From: [REDACTED]
To: [Longfield Solar Farm](#)
Subject: RE: Ref LOSF-001 Longfield Solar Farm
Date: 15 November 2022 15:43:07

Ref LOSF-001 Longfield Solar Farm

Applicants Document ref Longfield Solar Farm Works Plan 1 of 2 Doc Ref EN 010118/APP/2.2(B) Revision 3 dated October 2022 Page 7 of 9 work Plan. Further to my e mail to you on 2 November (below) I have had the opportunity to visit [REDACTED] at the weekend and view the area contained within Page 7 of the Applicant Plan referred to above.

TITLE: Works Plan Sheet 7

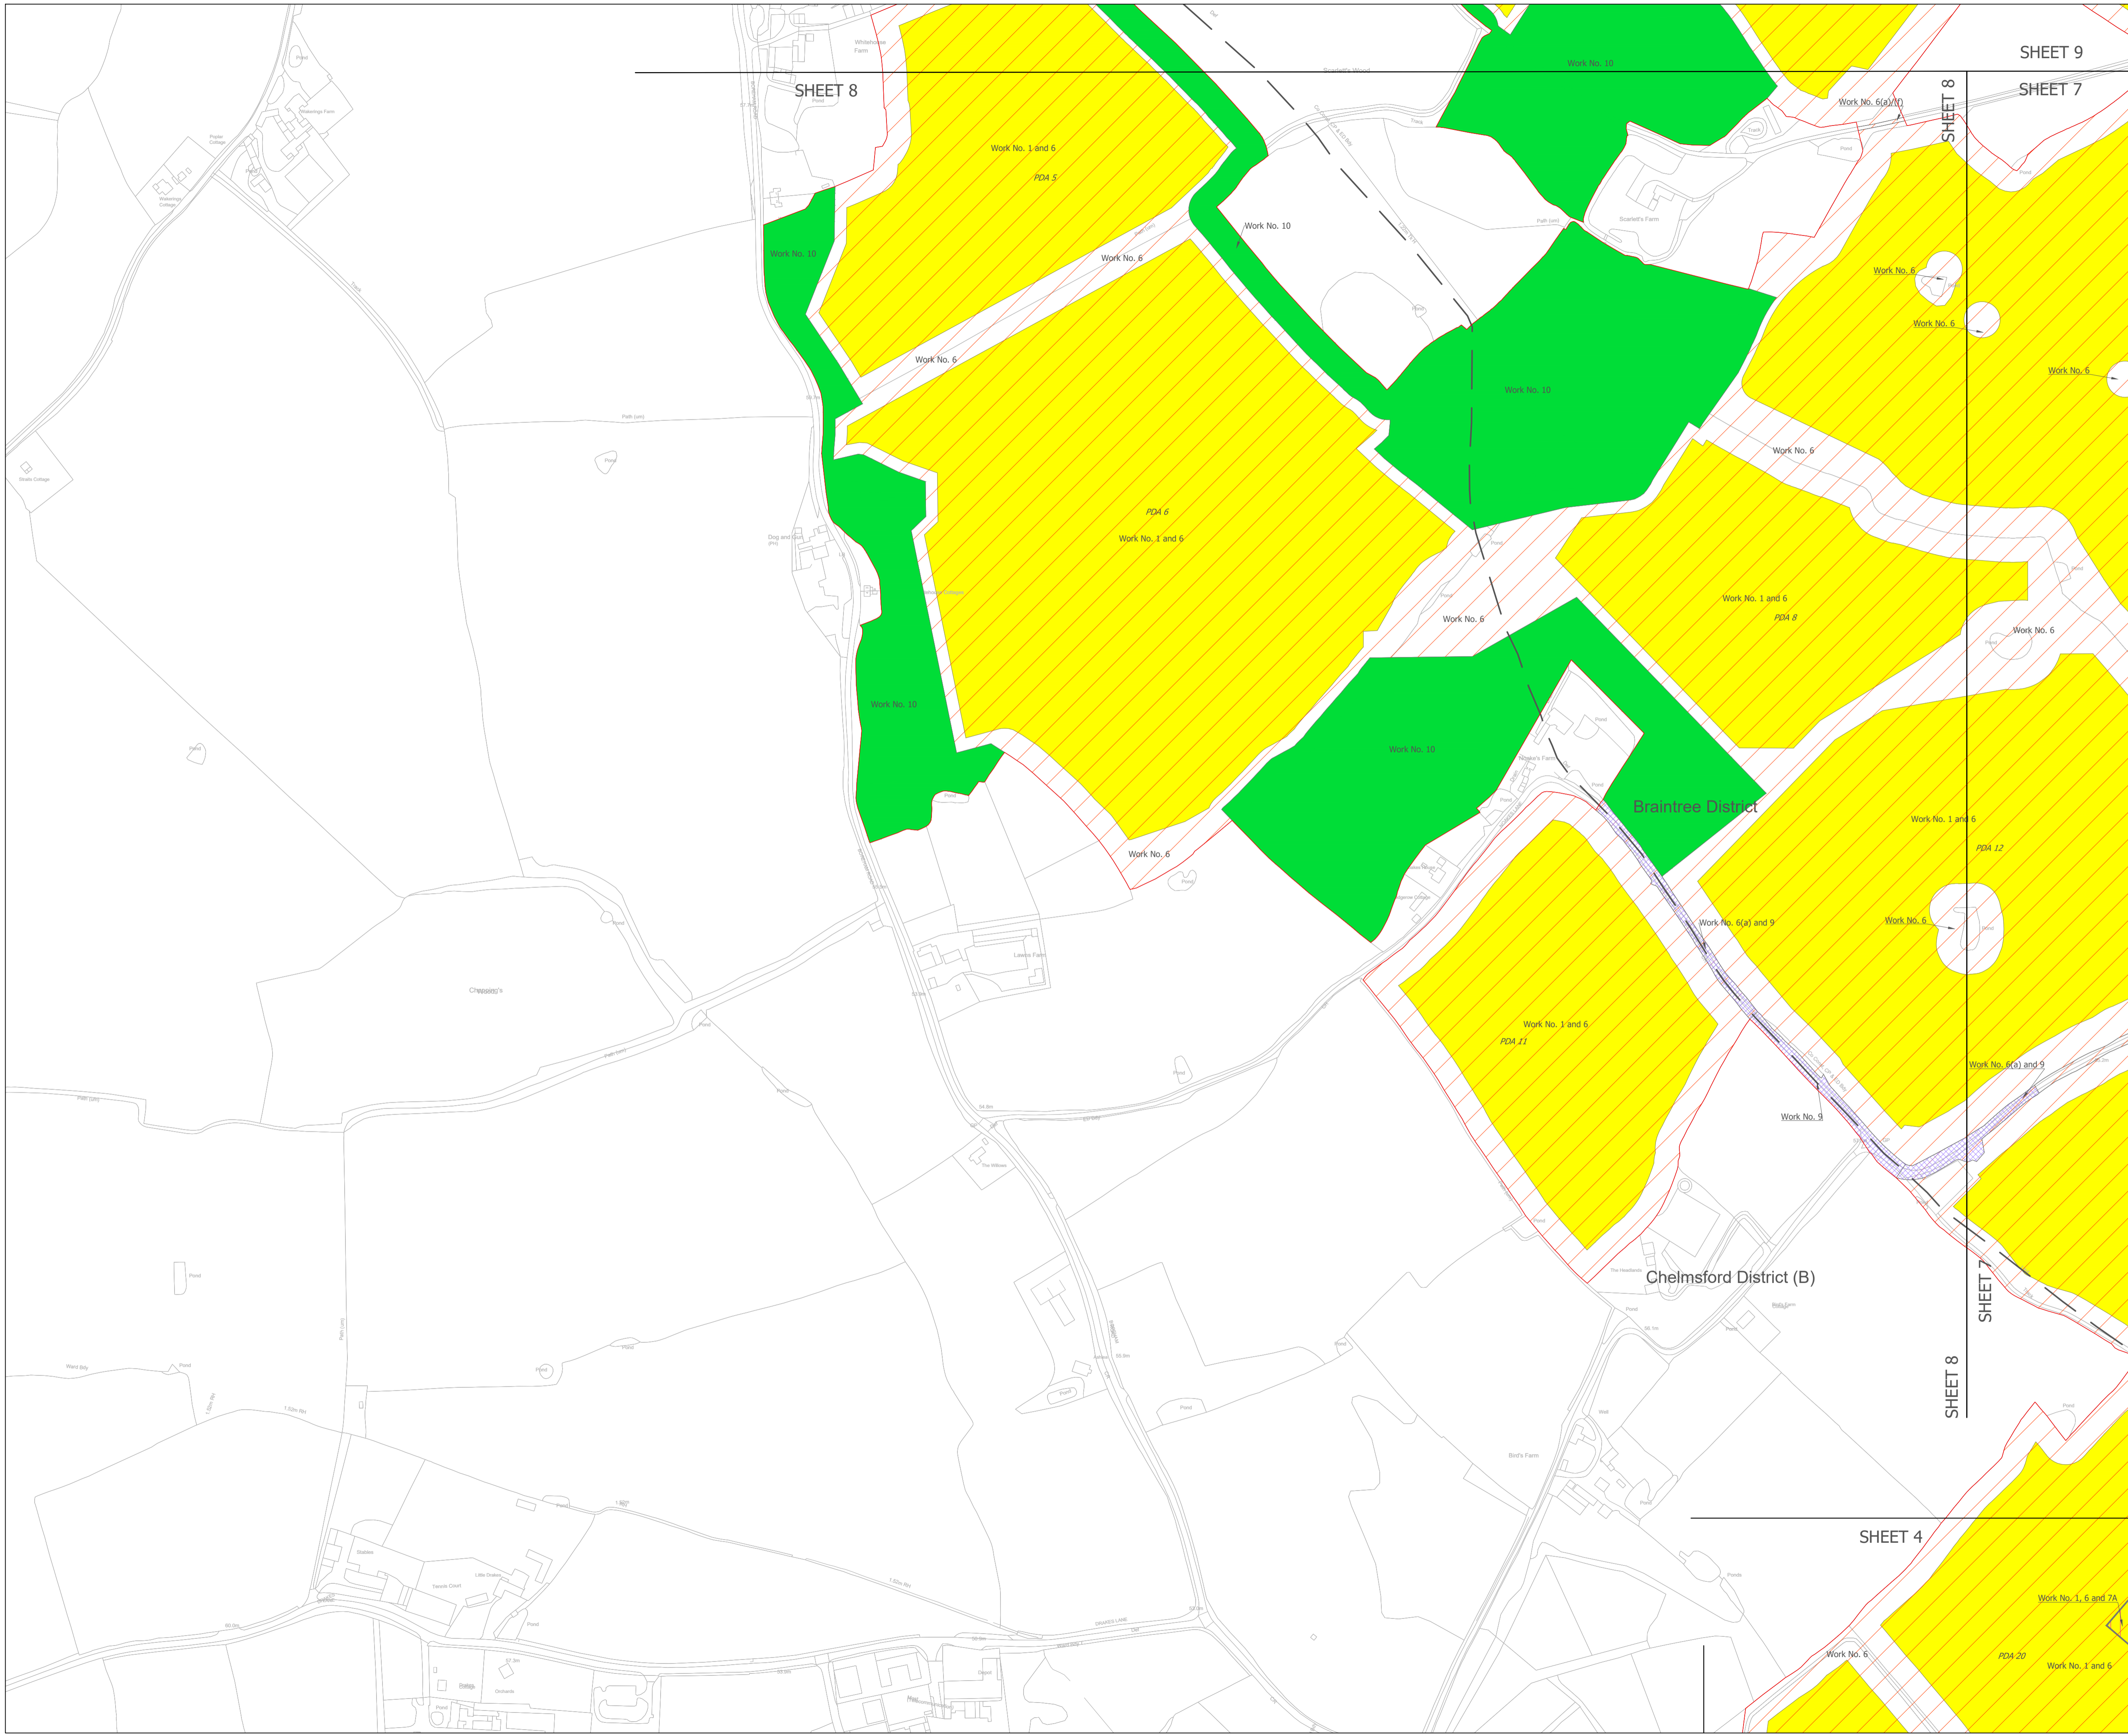
The Applicants Plan is misleading as it indicates a pond which is a land mark or marker to the extent of the proposed solar panel boundary fence contained directly opposite [REDACTED] within that Page 7 Plan Document.

As this field has been subject to an Autumn ploughing its clear there is no pond , just a minor earth hollow. Mr F G Bentley advised me that the pond was filled in some years ago.

We both felt that if this is the intended boundary area of the proposed Solar Panel field , then it is still too close to [REDACTED] and should be set much further back, to minimise its impact on the amenity of No [REDACTED] .

As it appears the applicant is using out of date plans for formal Consultation purposes, it would be helpful if any future plans actually set out the intended distance between those residential properties boundary fencing and the proposed Solar Panel fields boundary fencing.
